CITY OF PORTLAND, MAINE

October 11, 2017

Project Name: Onejoy Place Condominium - Twelve Unit Residential Building
Project ID: 2017-103 (Subdivision and Site Plan)
2017-128 (Conditional Use Inclusionary Zoning)
Address: 1 Joy Place CBL: 045 E049001
Applicant: Onejoy Place LLC
Planner: Jean Fraser

BRICK DRIVEWAY APRON

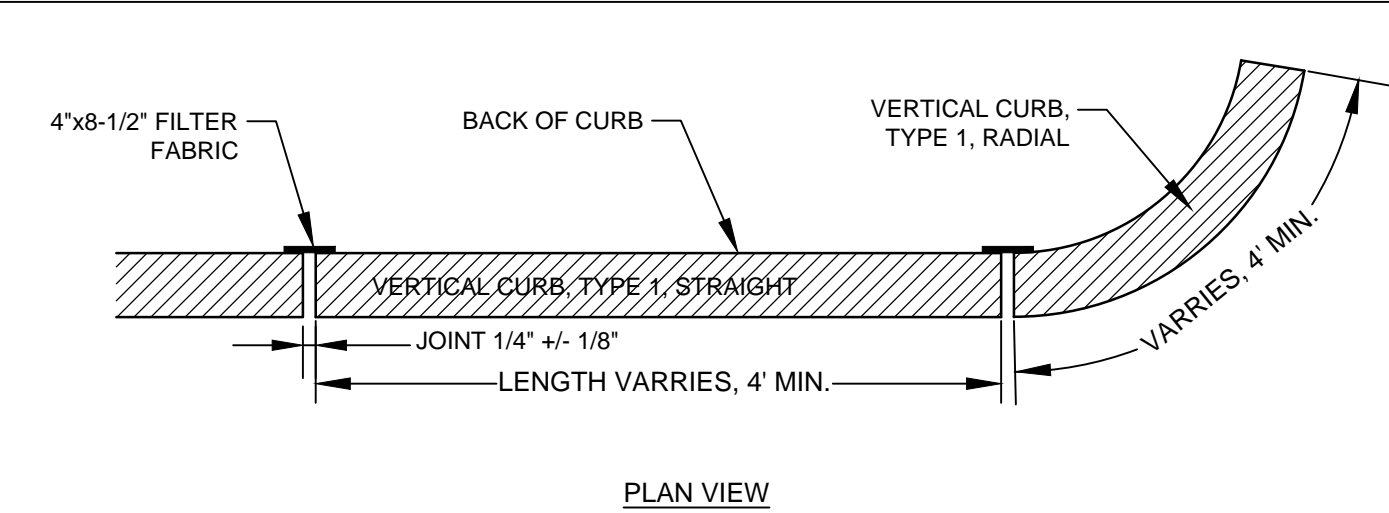
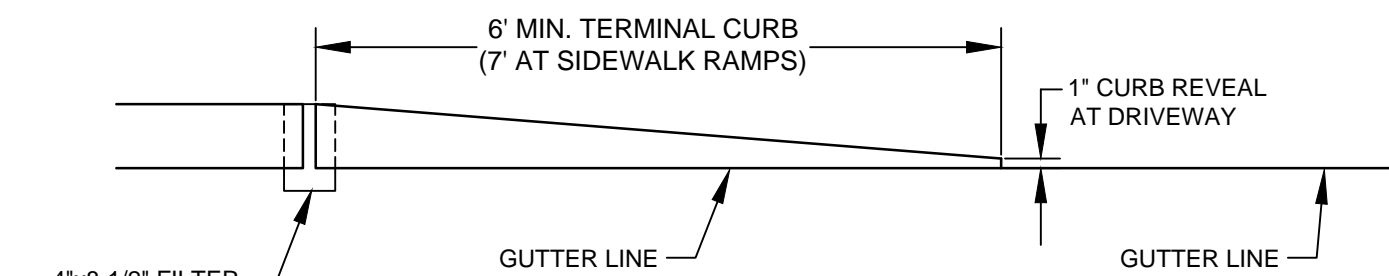
- viii. That the design of the apron and associated sidewalk shall meet Technical Standards and conform to the design detail provided in the final submissions (2% maximum cross-slope); and

- The driveway apron shall be designed to provide a maximum cross-slope of 2 percent along the pedestrian accessibility route.

Status: The applicant has noted in writing that a 2 percent pedestrian accessibility route cannot be provided along Brackett Street in the Joy Place driveway apron area. The applicant has provided a driveway design detail that specifies a maximum cross-slope of 2 percent for the driveway apron. A condition of approval should reinforce the requirement that the driveway apron shall conform to the design detail provided (2% maximum cross-slope).

LANDSCAPE PLAN

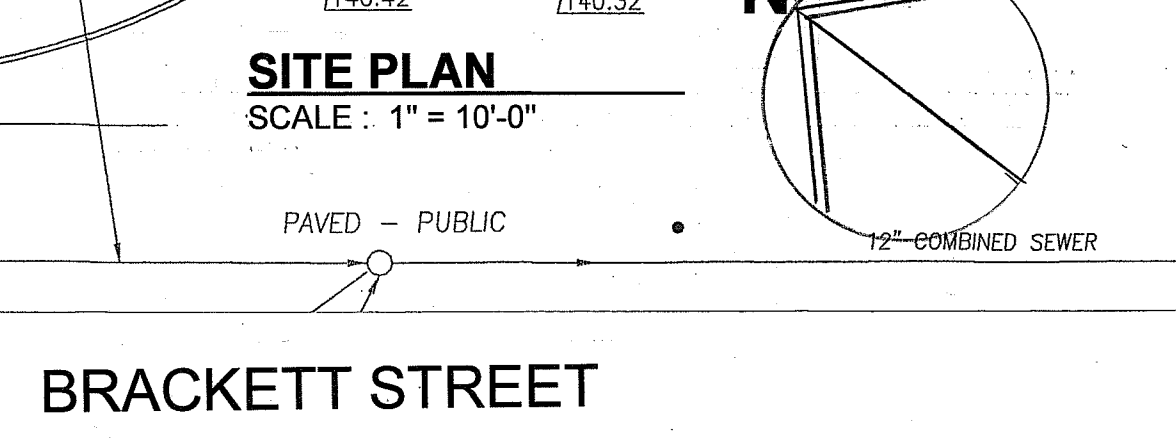
- v. That the Landscaping Plan shall be revised, for review and approval by the City Arborist and Planning Authority prior to the issuance of a building permit, to replace the Amur Maple with a species suggested by the City Arborist in his comments dated 9.21.2017; and

The project does have landscape challenges due to its unique site location and lack of street frontage. One suggestive comment would be to find a substitution for the Amur Maple as they tend to show up on the invasive plant list. Other suggestions might include 'Cornus mas', Hop Hornbeam, Cornelian Cherry Dogwood.
